# CITY OF PORTLAND BUILDING PERMIT

**PERMIT ID:** 2012-65529

has permission to **1st floor: build a closet, move 3 doors, change suspended ceilings to sheetrock (5/8"), and other work as shown**

**Dept:** Building      **Status:** Approved w/Conditions      **Reviewer:** Jeanie Bourke      **Approval Date:** 12/18/2012  
**Note:**      **Ok to Issue:**

109 Sheridan St. 1st floor

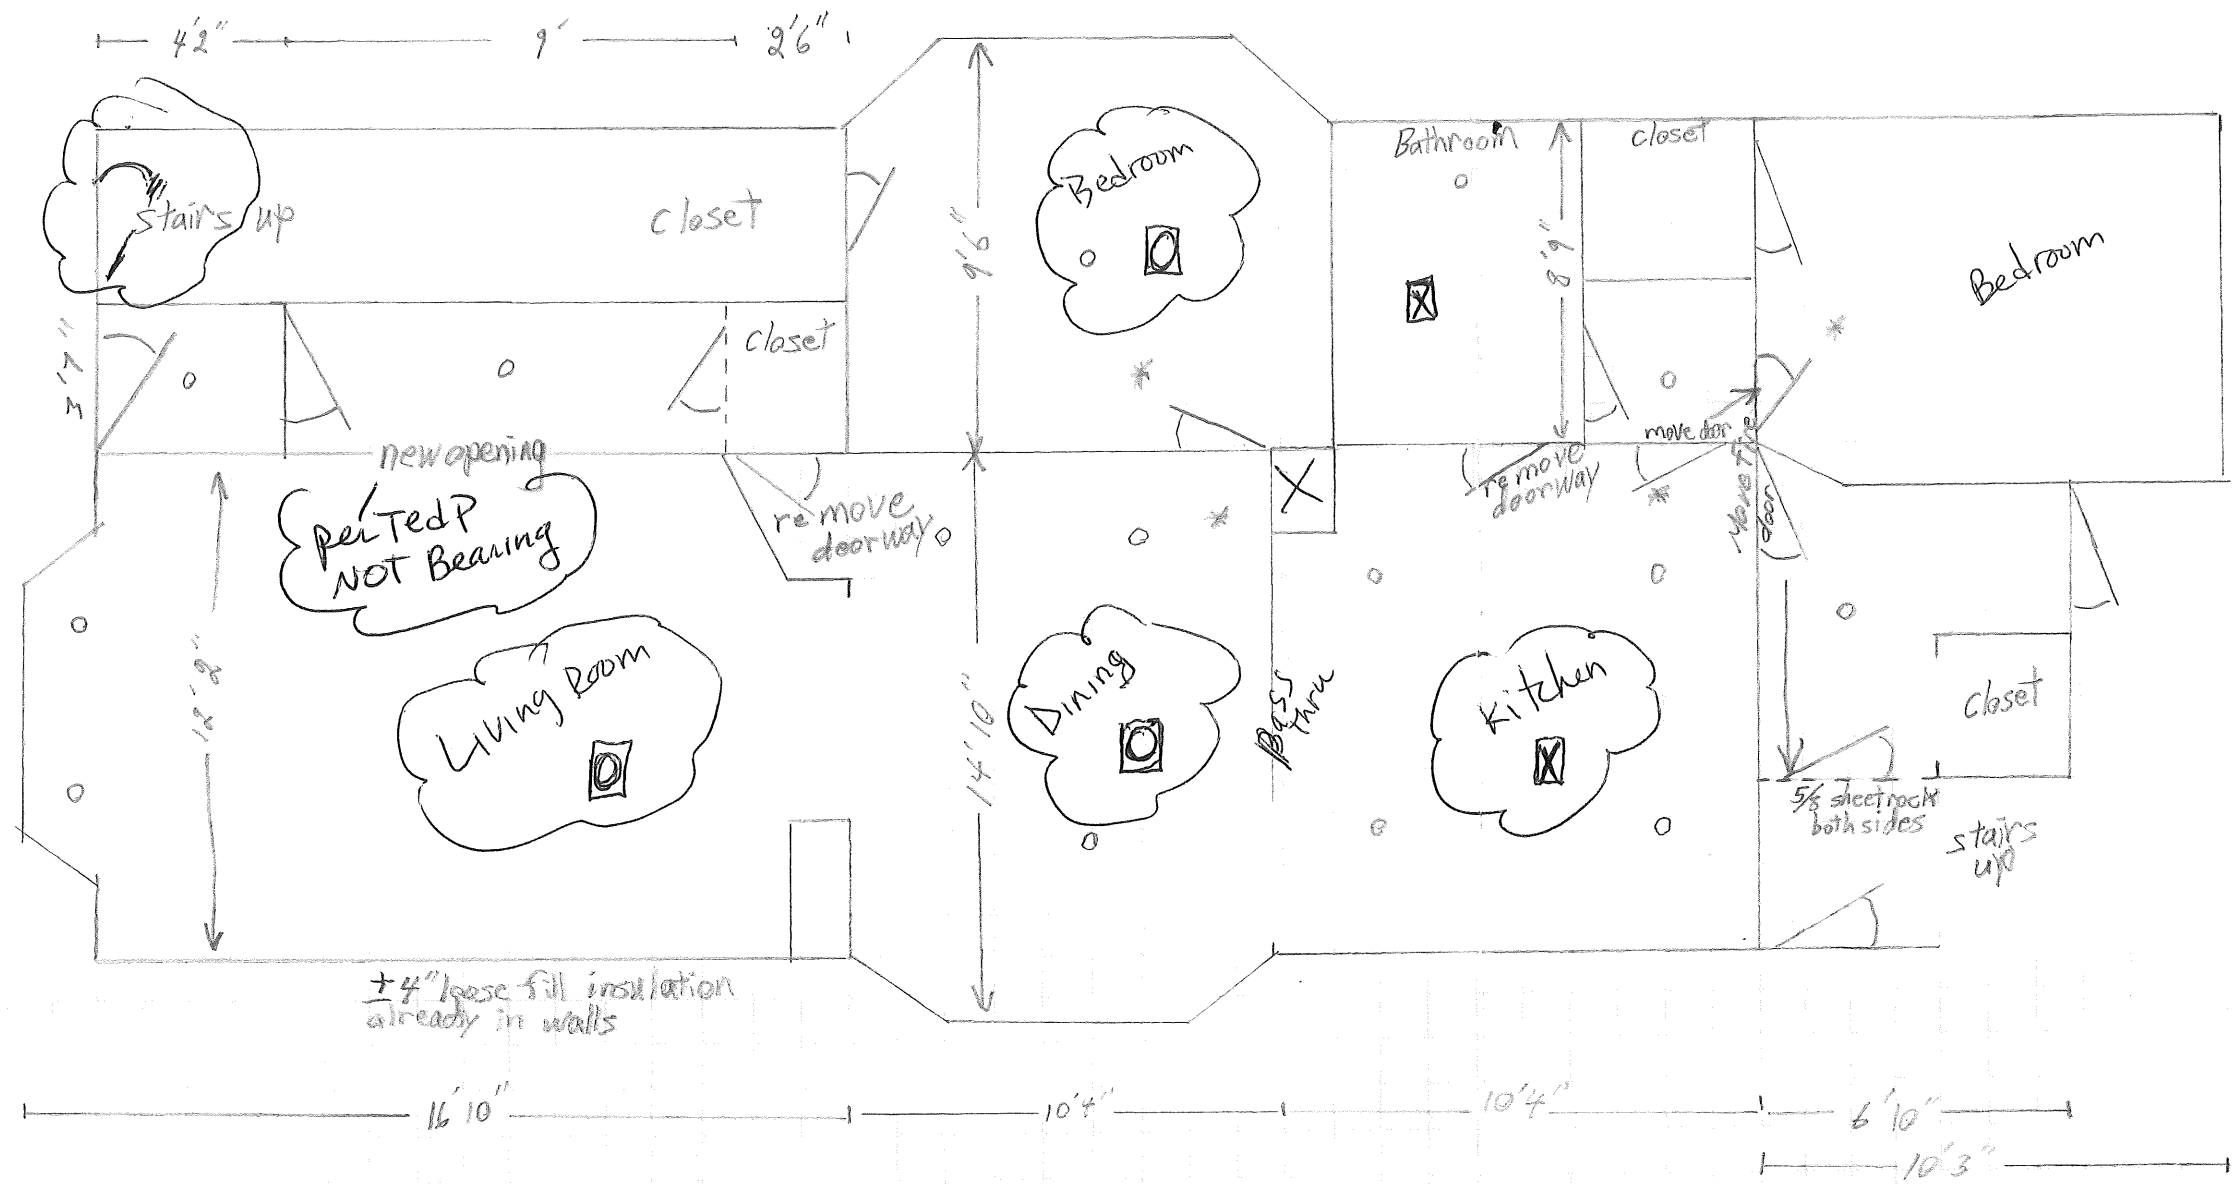
- 1) PER IBC SEC. 713.4.1.2(2), MEMBRANE PENETRATIONS OF FIRE RESISTANCE RATED ASSEMBLIES BY STEEL ELECTRICAL BOXES OR RECESSED LIGHT FIXTURES THAT DO NOT EXCEED 16 SQUARE INCHES IN AREA ARE ALLOWED ONLY IF THE AGGREGATE AREA DOES NOT EXCEED 100 SQUARE INCHES PER 100 SQUARE FEET OF CEILING AREA. BOXES OR FIXTURES THAT EXCEED 16 SQUARE INCHES SHALL BE RATED TO MAINTAIN THE FIRE RESISTANCE RATING

- 2) All penetrations between dwelling units and dwelling units and common areas shall be protected with approved firestop materials, and recessed lighting/vent fixtures shall not reduce the (1 hour) required rating per IBC Sec. 712.

- 1) Single- and multiple-station smoke alarms shall be provided in each sleeping room and outside of each sleeping room inside the dwelling units. They are not required in the common areas outside of the dwelling unit. New smoke alarms shall be hardwired with battery backup and photoelectric. The unit undergoing renovation shall have the smoke alarm interconnected so that if one alarms they all alarm.

- 2) Doors between the exit stairs and dwelling units, storage ares, and basement shall be existing approved 45-minute fire door assemblies or 1-hour fire door assemblies if not existing approved.

- 3) Through-penetrations and membrane penetrations in fire walls, fire barrier walls, and fire resistance rated horizontal assemblies shall be protected by firestop systems or devices in conformance with NFPA 101:8.3.5 (ASTM E 814 or ANSI/UL 1479). Providing firestop labels at each firestop system or device and an onsite manual containing the detail for each firestop system or device used for the project will streamline final inspection approvals.
